**WEST SUSSEX COUNTY COUNCIL
STRATEGIC PLANNING CONSULTATION**

SUBJECT: FG/26/15/OUT - Erection of 1 No. four bedroom dwelling.

Eastlands, Littlehampton Road, Ferring, Worthing, West Sussex, BN12 6PB

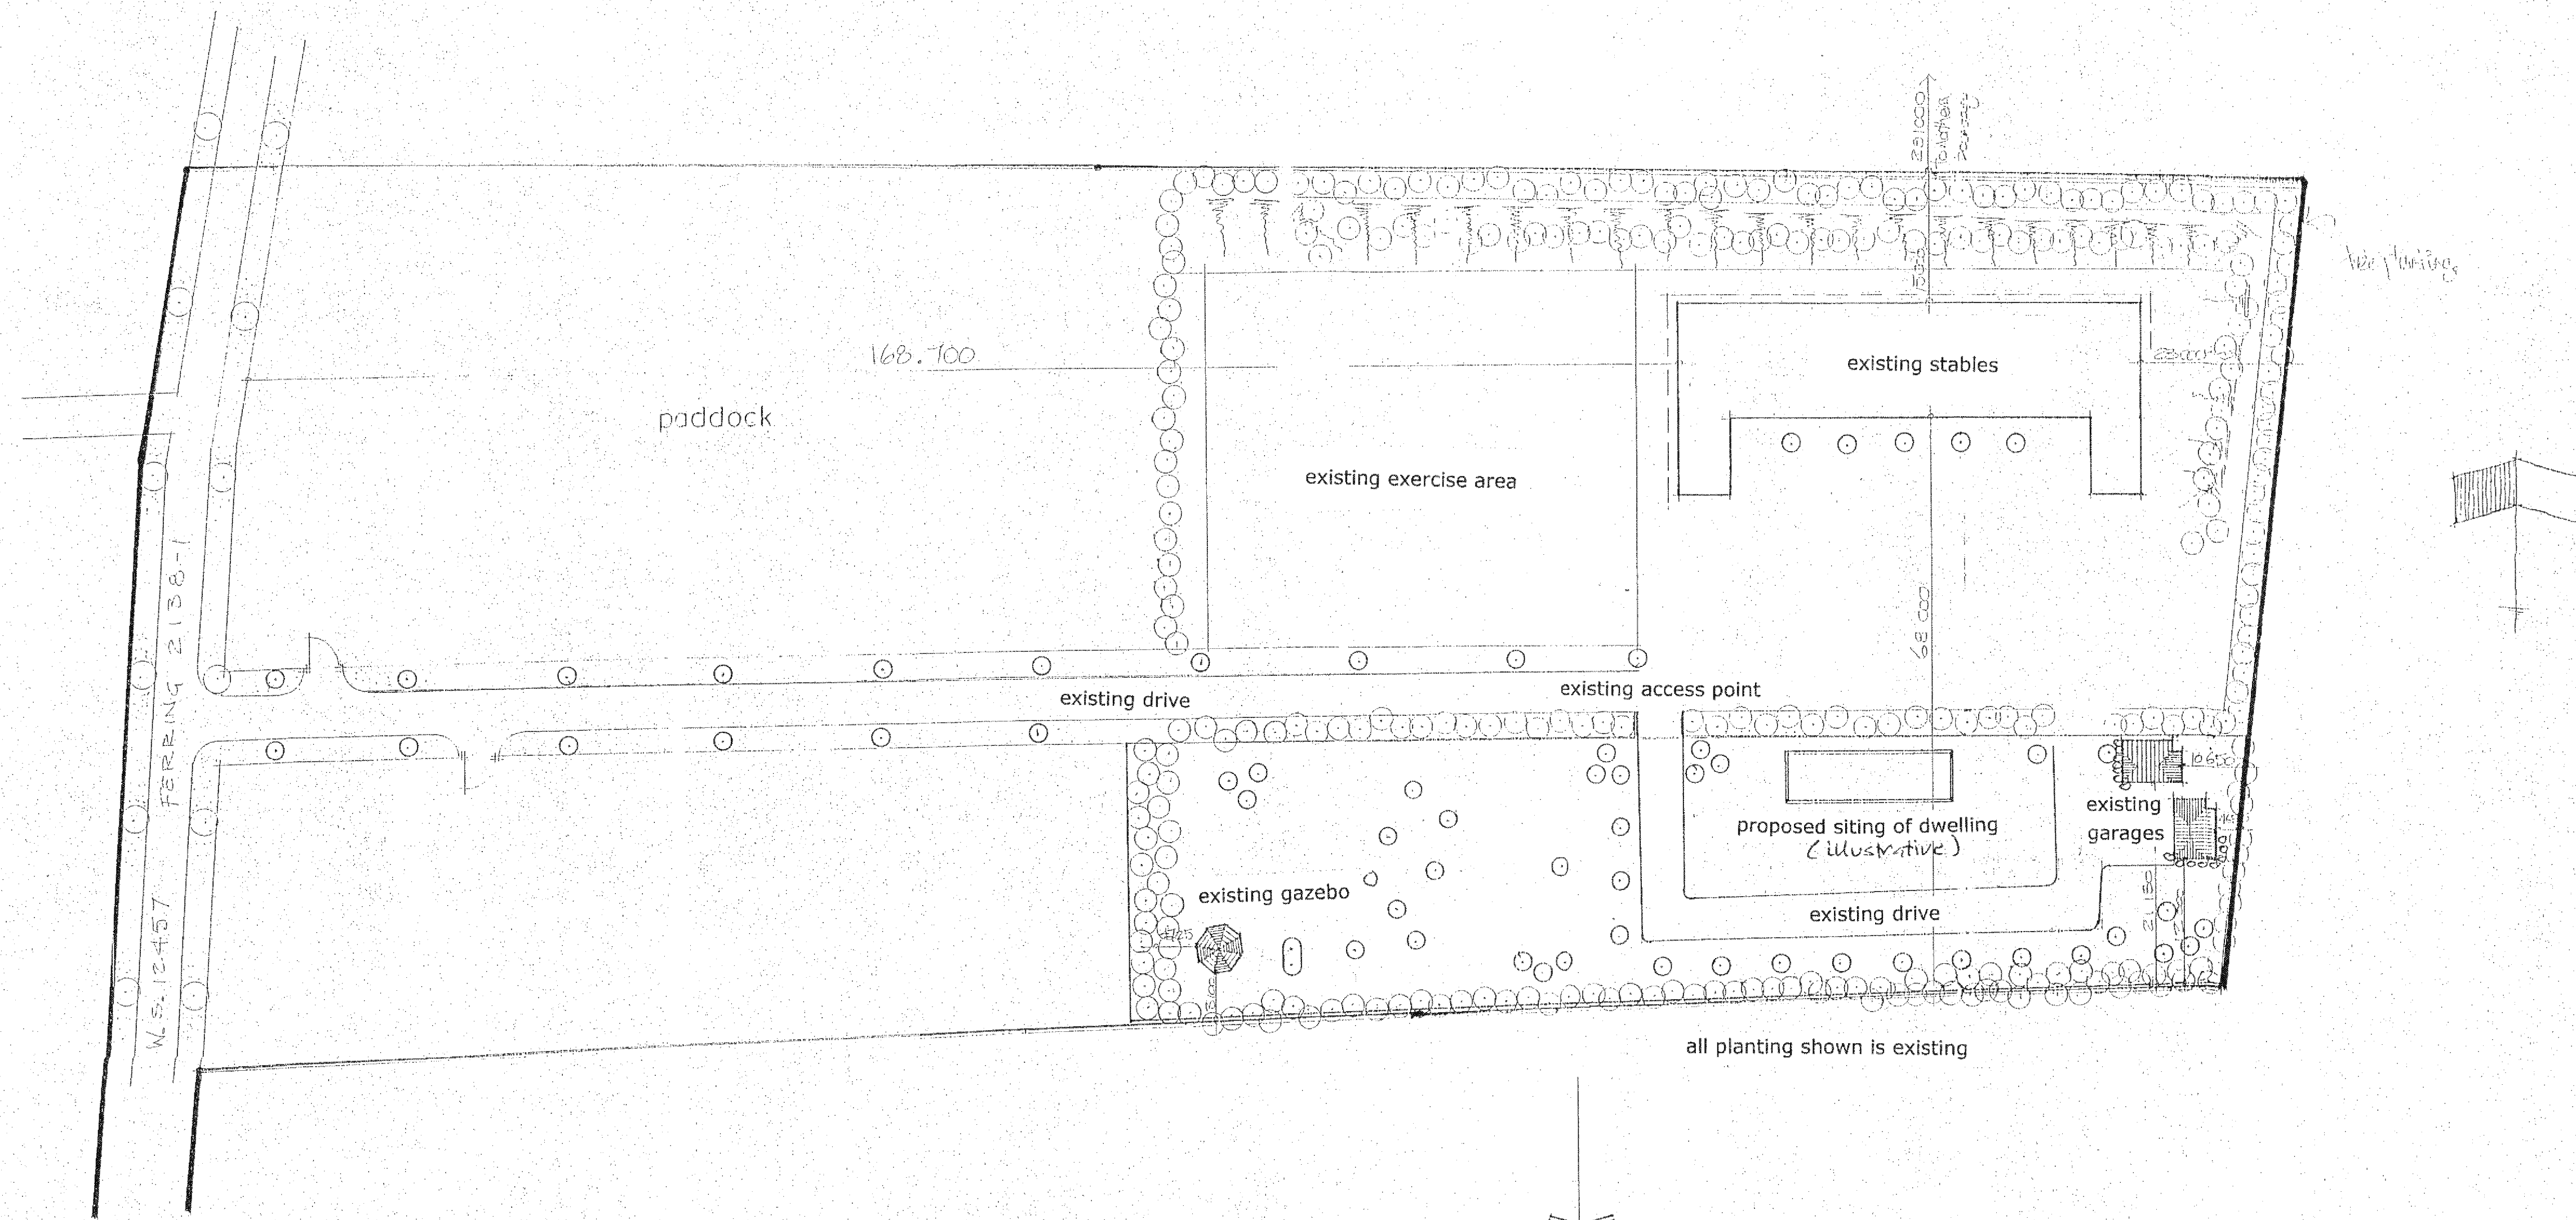
The proposal is for a single dwelling unit with access onto Littlehampton Road via an existing access point. From an inspection of the plans alone, there is no apparent visibility issue at the point of access onto Littlehampton Road. The most recently available verified accident records reveal there have been no personal injury accidents in the vicinity of the existing point of access, indicating a low risk of highway safety issues with this proposal.

The application site is not especially sustainable as it located off of a busy dual carriageway, with a lack of metalled footways or cycle ways in the vicinity. This would mean that a large number of movements from the site will be reliant on the motor vehicle

There are no Highway safety concerns with this proposal.

No part of the development shall be first occupied until covered and secure cycle parking spaces have been provided in accordance with plans and details submitted to and approved by the Local Planning Authority.
